PLANNING APPLICATION REPORT**REF NO:** BR/219/11/**LOCATION:** 1 The Steyne
Bognor Regis**PROPOSAL:** Convert trading area to 2no. studio flats. Relocate bin stores approved under planning application BR/8/10 - Resubmission of planning permission BR/133/11**SITE AND SURROUNDINGS**

Proposed Ground Floor Plan

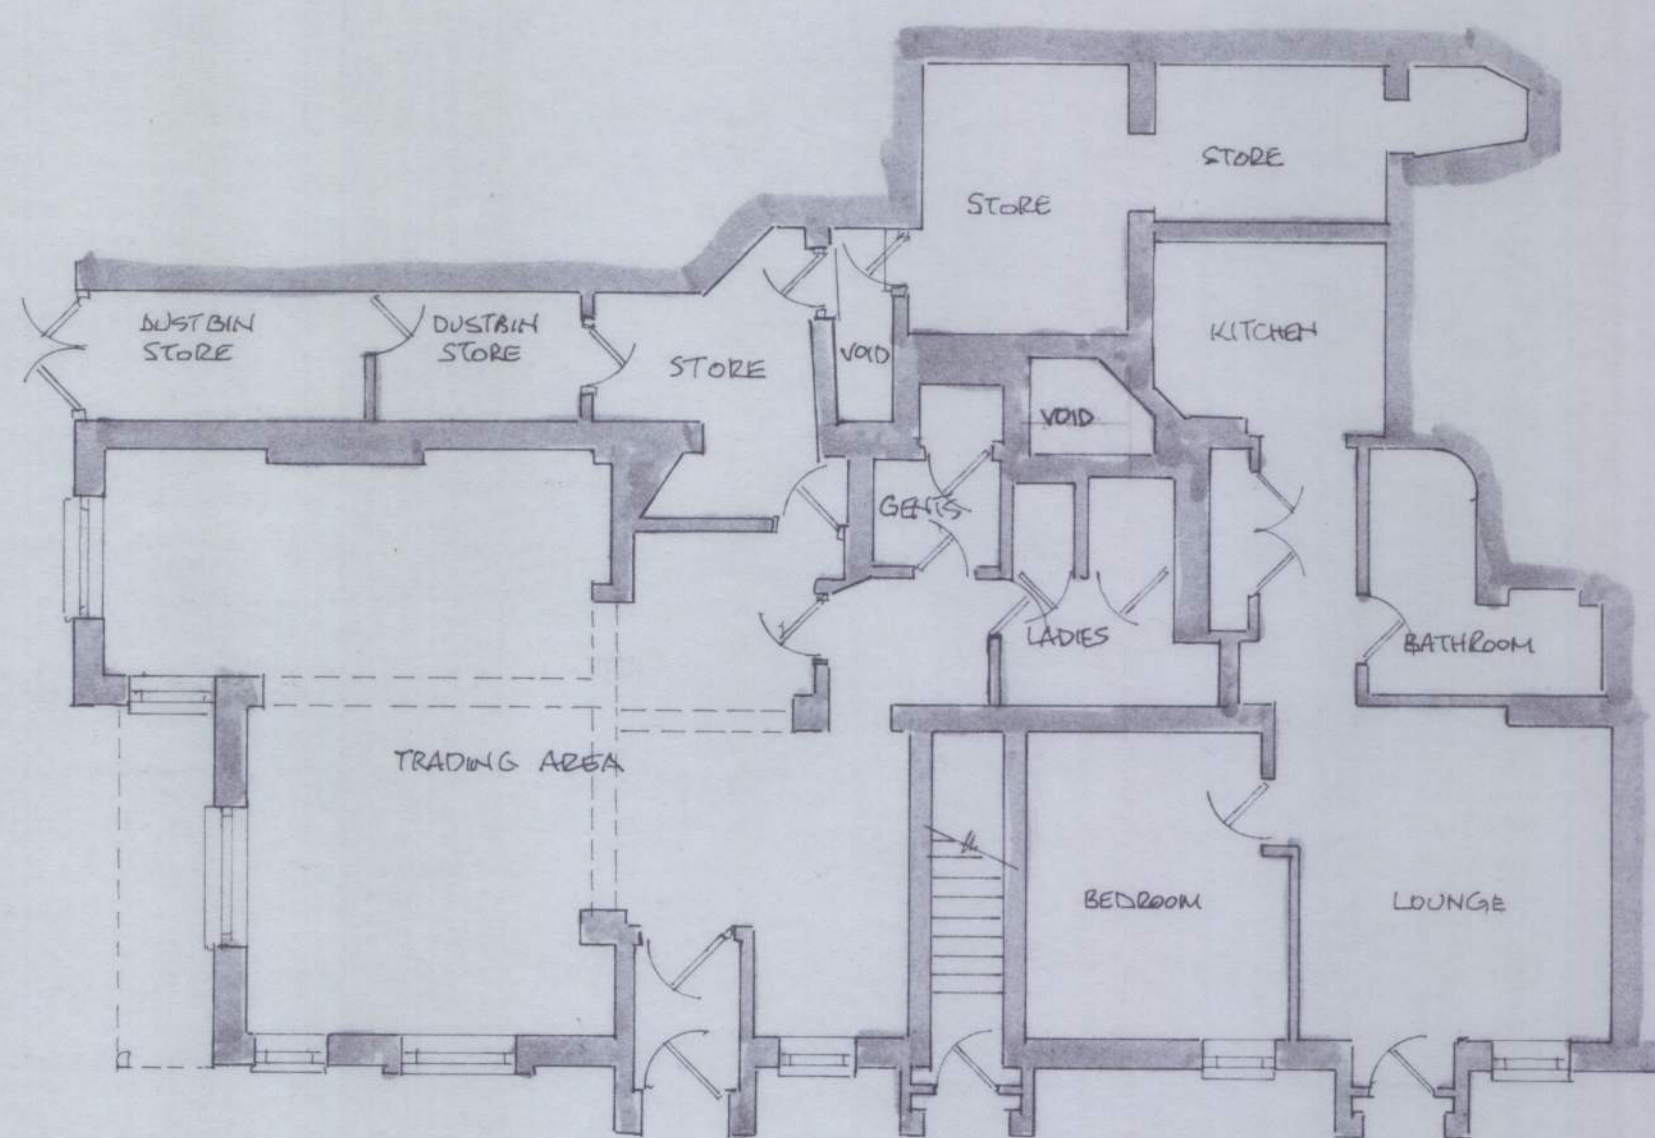
County Highways: Taking into account the sites previous use, there would be no concerns with this proposal from a highway safety point of view. Cycle parking must be provided.

Comments noted. The plans show an enclosed, lockable cycle compound.

It is this section which is subject to the current application, the reason for the application being that no one has taken up the premises for the commercial use, together with the fact that in discussions with the fire service, the applicant was informed that there were problems with achieving egress from the rear storerooms.

The change of use of this section of the property will not adversely effect either the character or the amenities of its eclectic surroundings, indeed, the only external change would be to the fenestration together with the change from timber doors to side walkway to a wrought iron double gate. The windows proposed will accord with other windows within the building and the locality.

- 4 Before the flats hereby permitted are occupied, the dedicated bin and bicycle storage area, shall be put in place fully in accordance with the approved plans.

Proposed West Elevation
(THROUGH PASSAGEWAY)

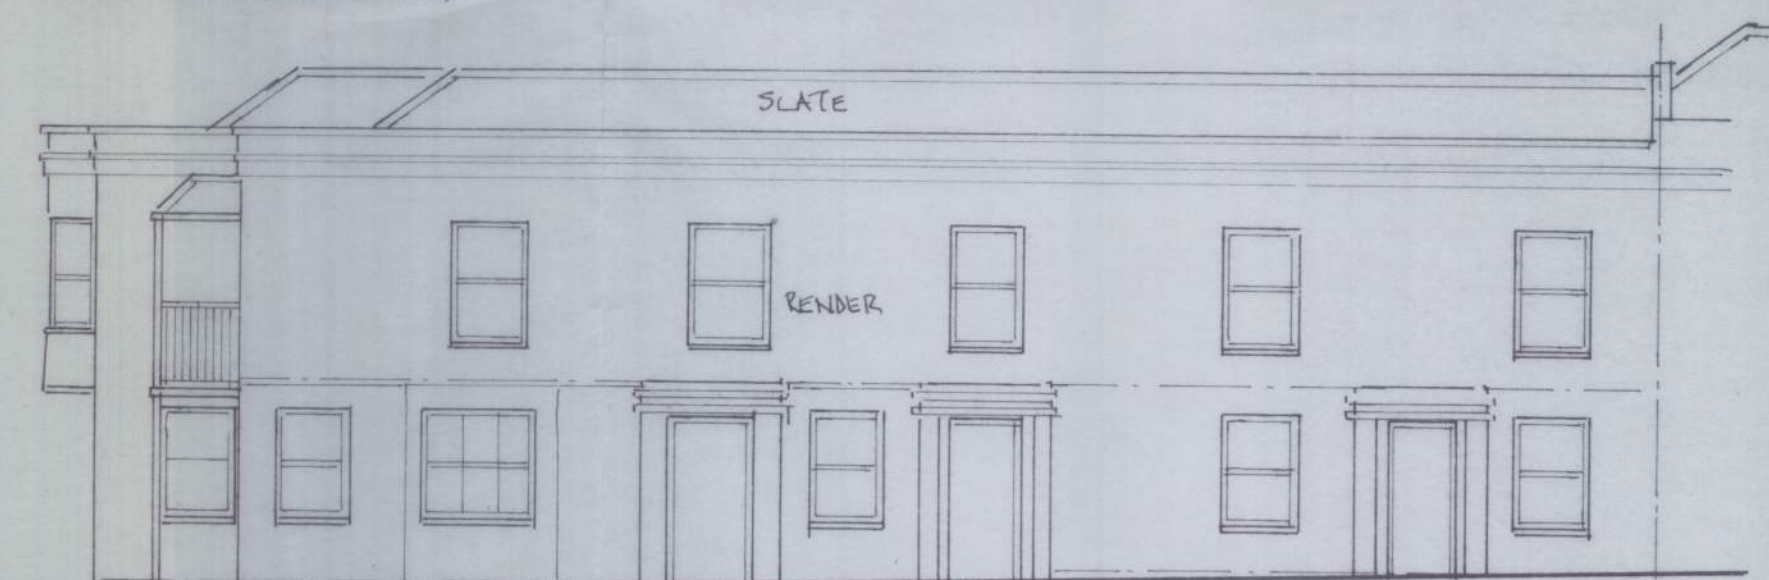
It is not considered that the character of the Conservation Area will be harmed in any manner, the building will largely remain the same, with the external differences being altered fenestration together with the provision of wrought iron gates to replace the rather poor looking doors to an existing dustbin store area.

- 3 All windows and doors shall be of painted timber.
